Application No: K/1/22/HH
Site Address: Nantucket Gorse Avenue East Preston BN16 1SG
Description of works: Proposed outbuilding to supersede previous outbuilding consented under application reference No. K/23/19/HH.

Thank you for your internet representation made on 23rd March 2022 which has been recorded as an objection with the comments as follows:

Council objects to this application for an outbuilding that comprises a sitting and kitchen area with a WC/shower room.

Drawing Name
**Site Plan -
Proposed**

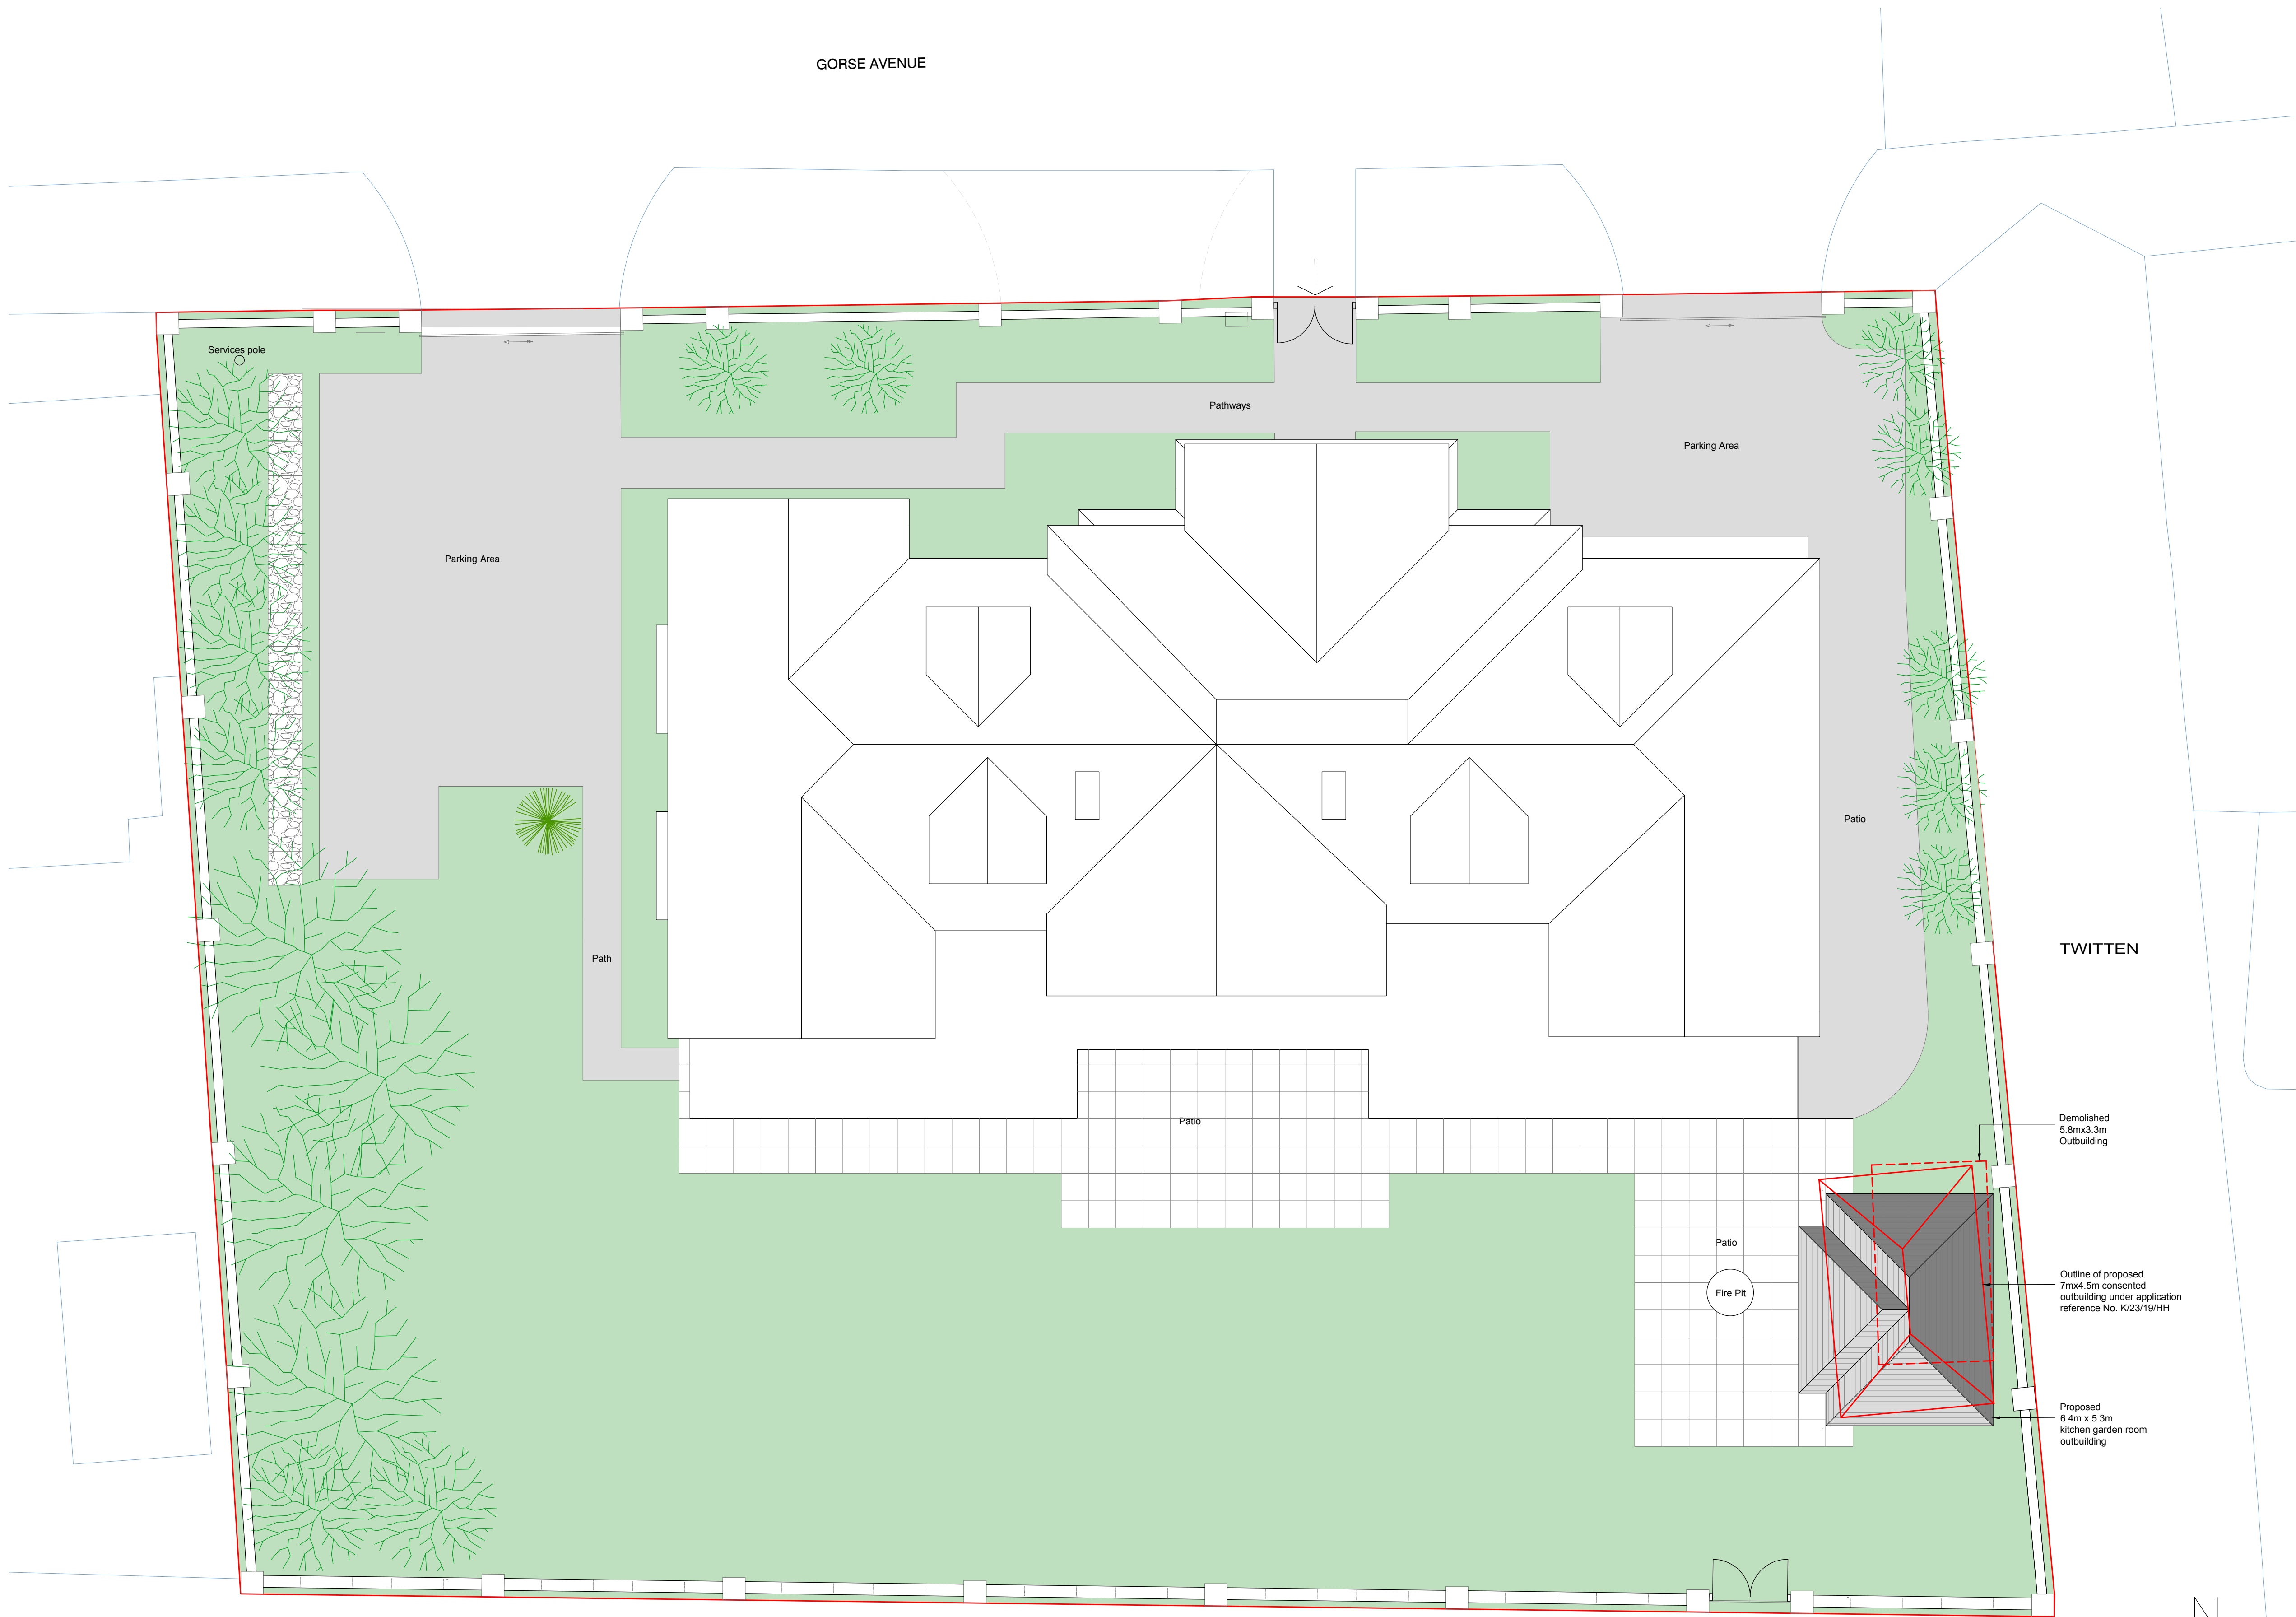
- close to the southern boundary of the property that abuts a popular leisure walk along the greensward (public footpath 2110) enjoyed by residents of the parish and many visitors to the parish, and

- it is even closer to the twitten that runs along its eastern boundary.
- v) it is out of character for the area given its design, size and proximity to boundaries and Council is concerned that for the reasons given above this would set an unwelcome precedent for an outbuilding.

Drawing Name	Floor Plans and Elevations - Proposed
--------------	--

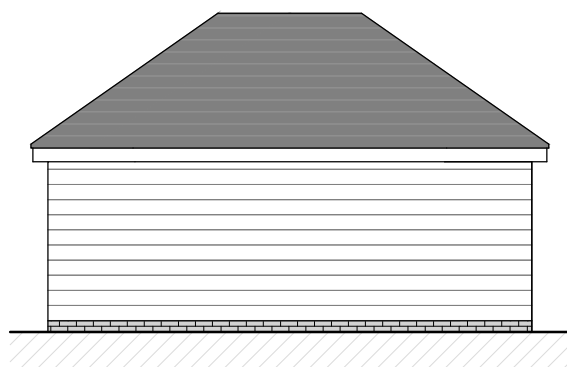
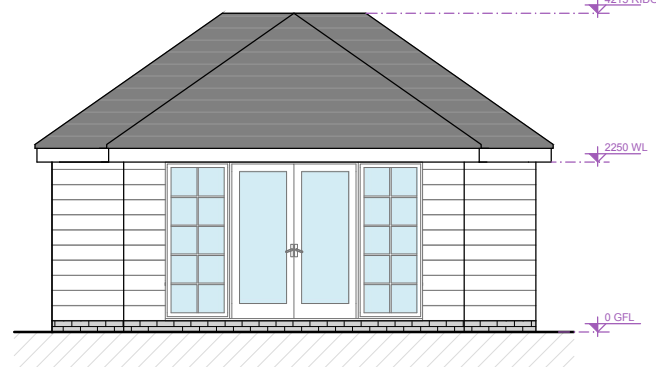
- i) it is an overdevelopment of the site
- ii) due to its height and mass and location on the plot it will be detrimental to the visual amenity and overall character and amenity of the neighbourhood. It is noted that it will be significantly higher than the boundary wall reaching a height of 4.215 m. This is also significantly higher than the flat roof summer house in the grounds of the neighbouring property to the west (High Hobby).

Council further comments on the reference to planning application K/23/19/HH. This substantial outbuilding was not included in the description of the proposed application and was not shown at all on the perspective or elevation views.
